DDA Compliance Statement

DDA Compliance Statement – Performance Solutions Stage 2 DA Submission-Final

Project: West Sydney Stadium

Date: 22nd February 2017

SHEET TITLE
GA PLAN
MEDIA LEVEL
LEVEL 04 - OVERALL
RL 29.07

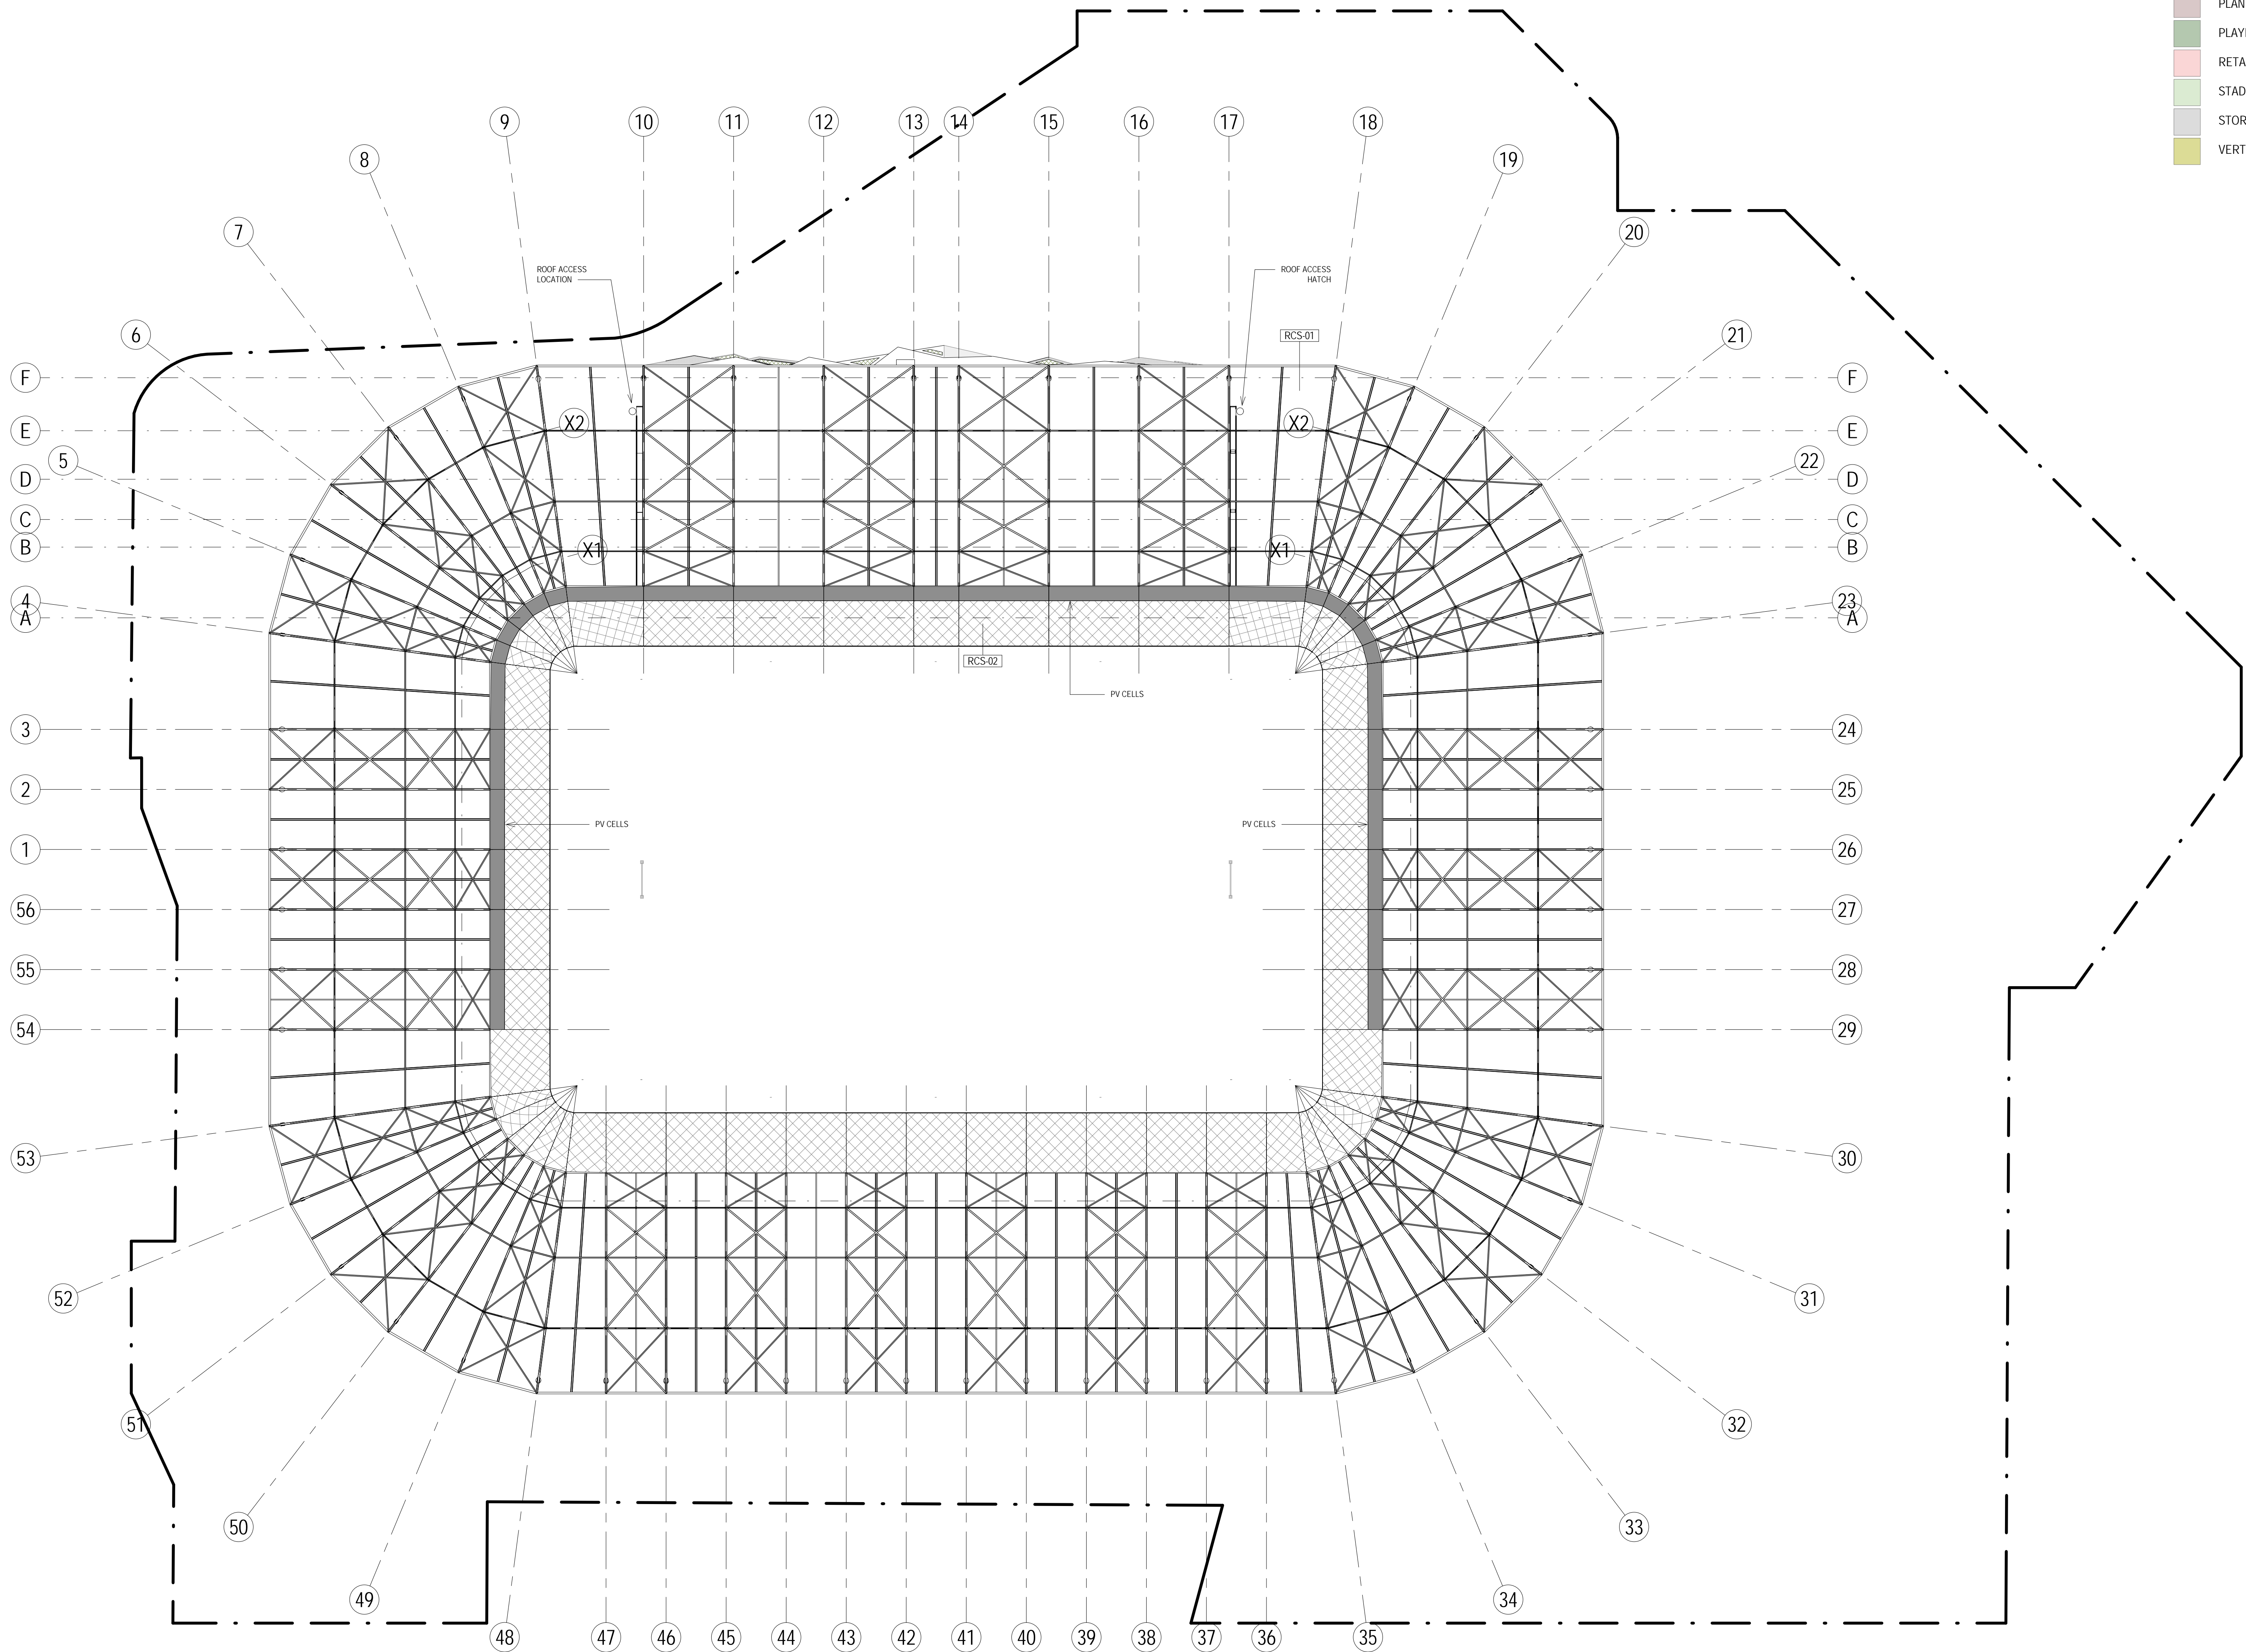
- The stadium comprises a concourse level with west and eastern drop-off zones. The West stands consists of 5 levels including basement level. PWD seating around plaza level on ground for main GA bowl, plus seating in Club levels and within suites. Media level (L4) will require access into each media area/room and associated toilets.
